# CITY OF ALBUQUERQUE

June 23, 2022

RE: **Lot 22 Block 6 Volcano Cliffs Unit 22 SAD 227**  
**8009 Camino Alto**  
**Grading and Drainage Plan**  
**Engineers Stamp Date 6/7/2022 (E10D077)**  
**Pad Certification Date None**

GRADING AND DRAINAGE PLAN

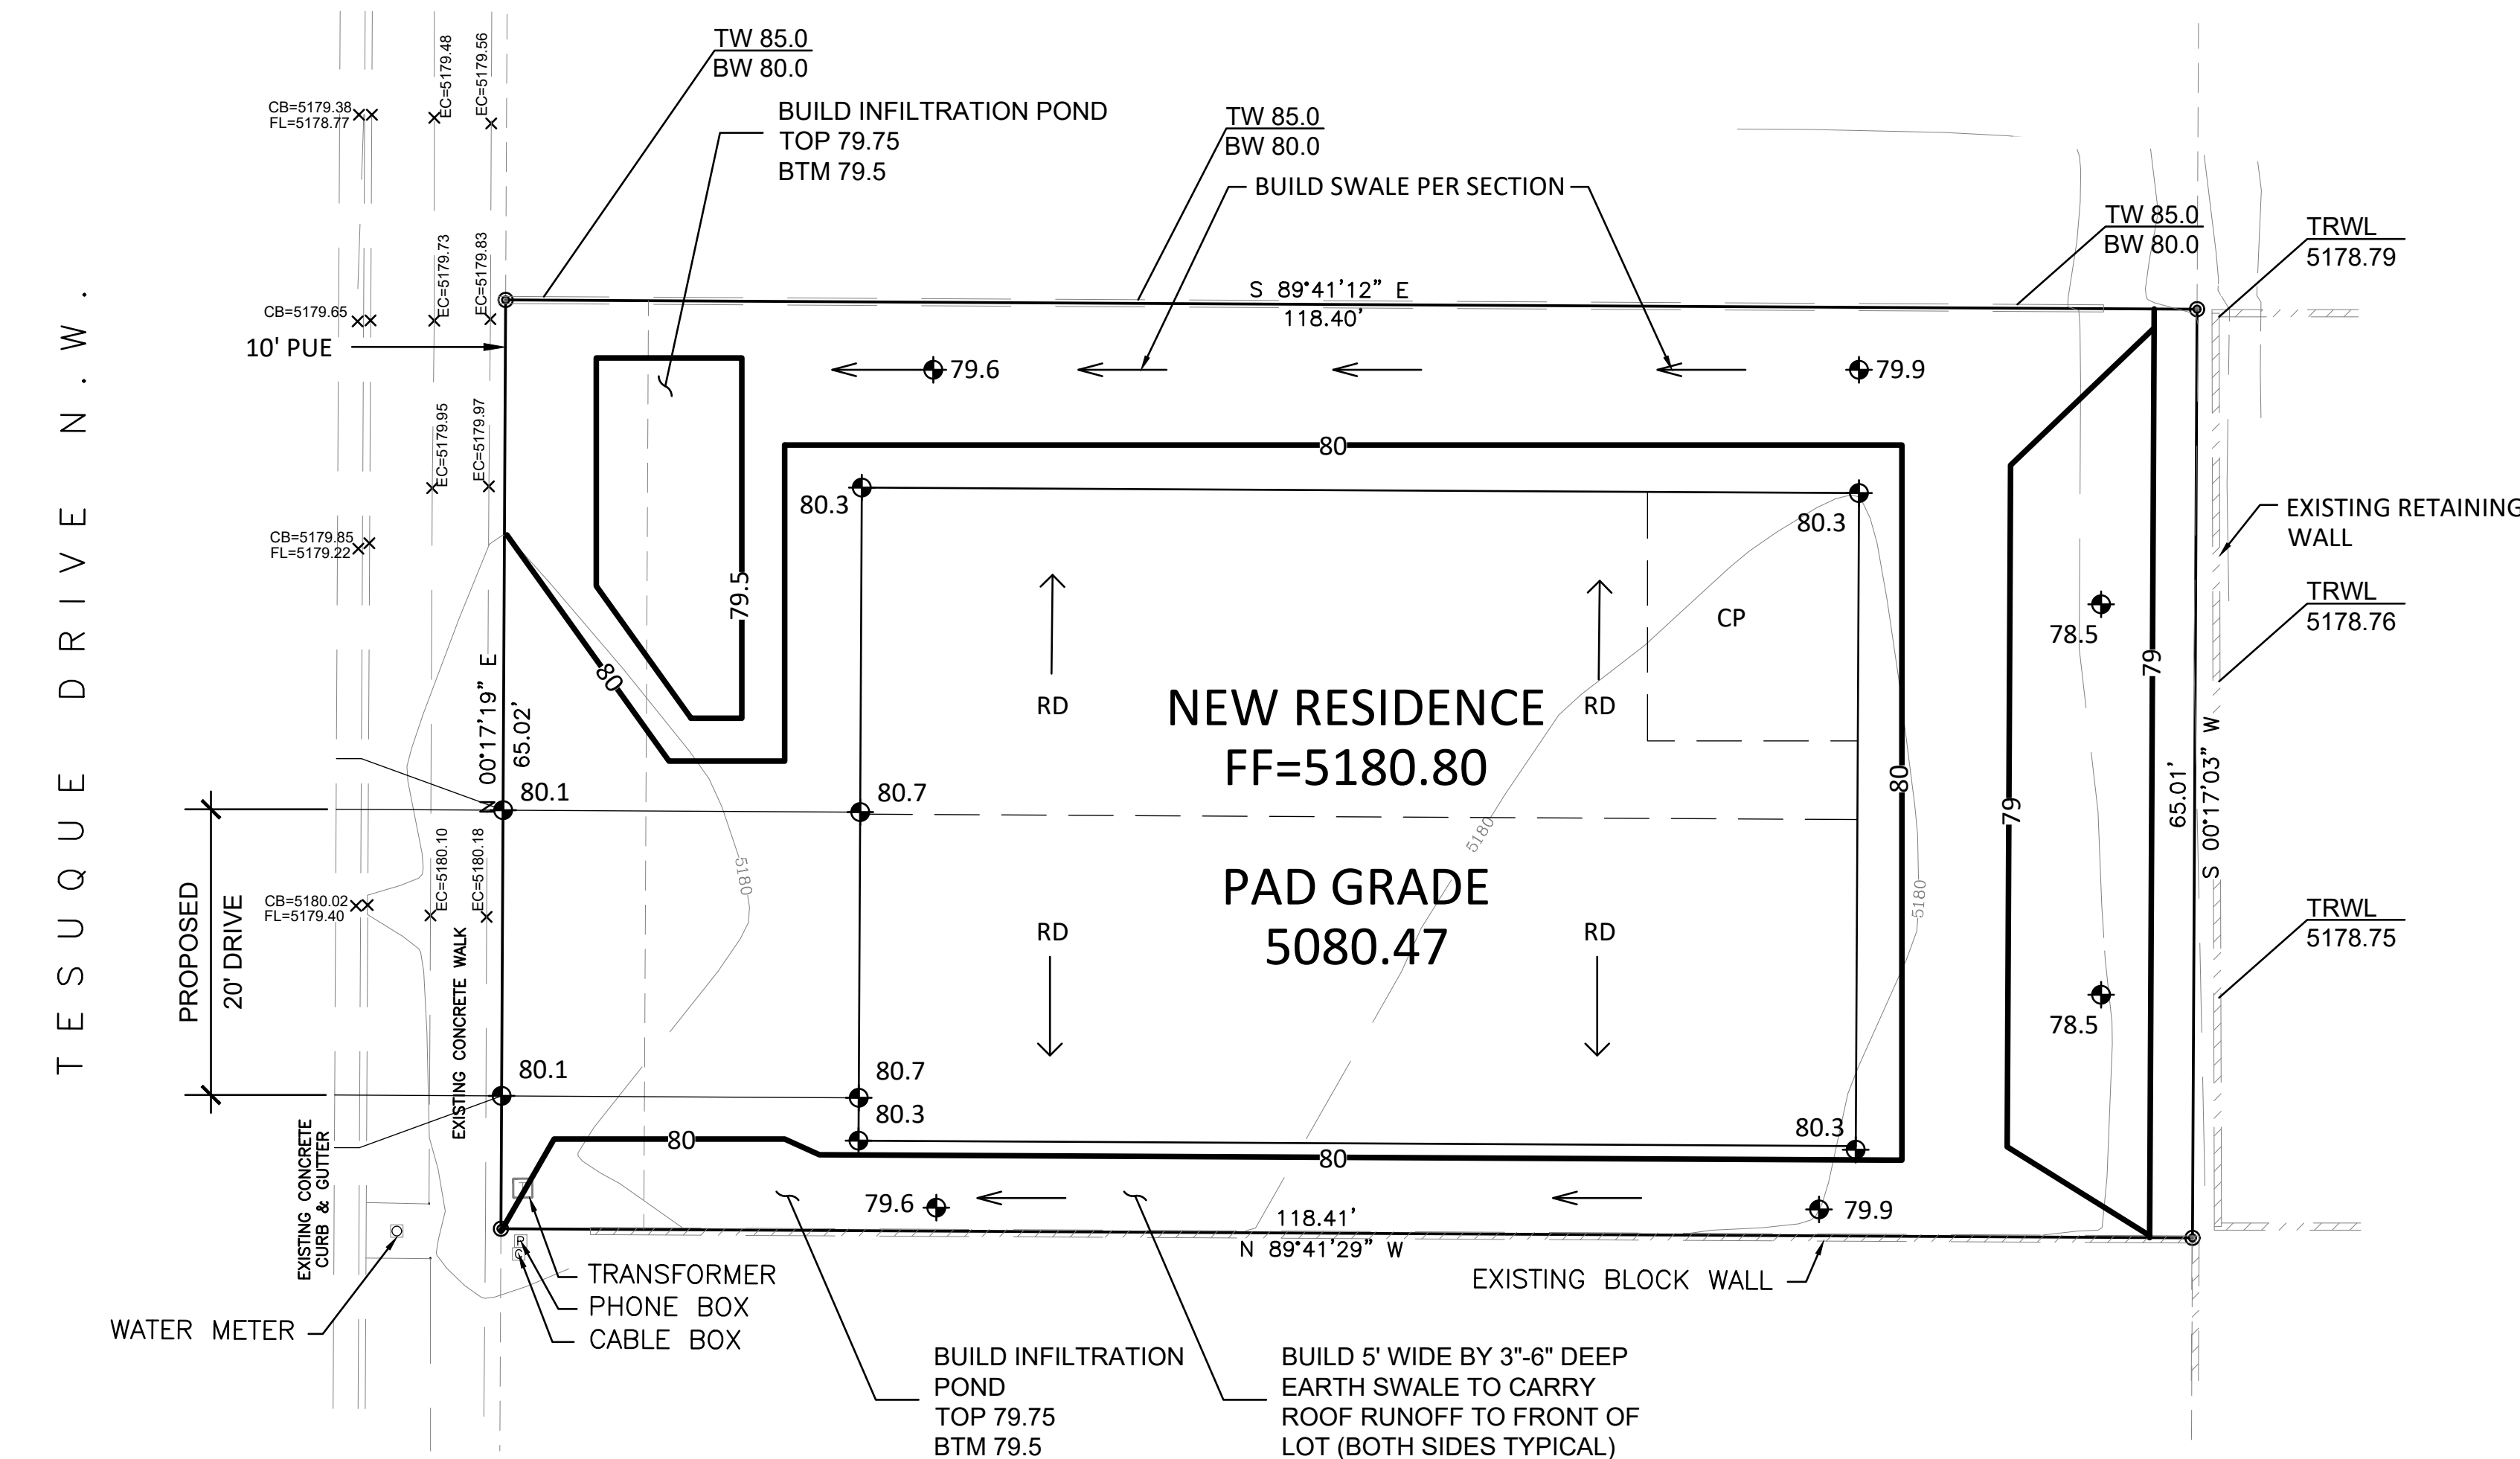
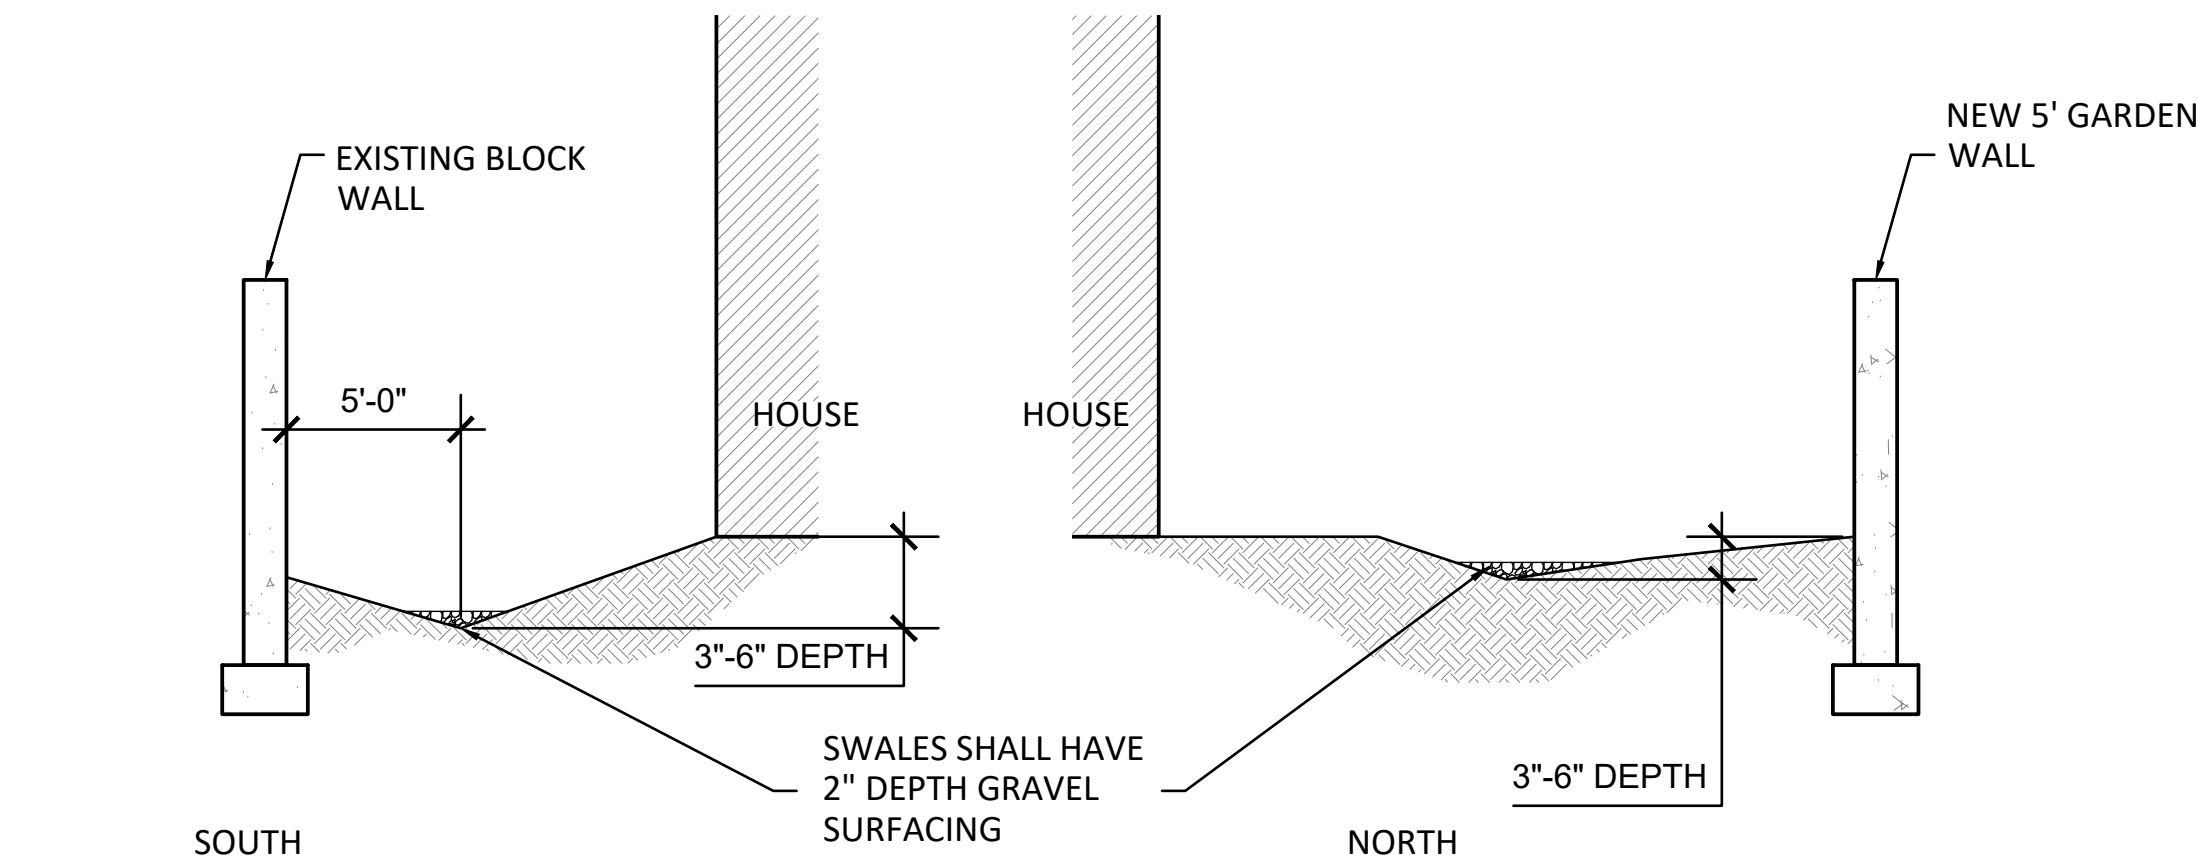
- Provide a table with land treatments, those that are allowed and those which are applied to this plan. This is in SAD 227; these land treatments should be followed.
- Inform Owner/Contractor not to use dirt as a ramp to climb curbing or drive over the sidewalk. Only crusher fines or lumber may be used for this process.
- Provide ponds in the front yard for filtration of water before water exits onto public right of way.
- Provide the SFHA map for this area.
- Provide the Pad Certification language.
- Provide a note that the swales are to be filled with gravel of some sort.
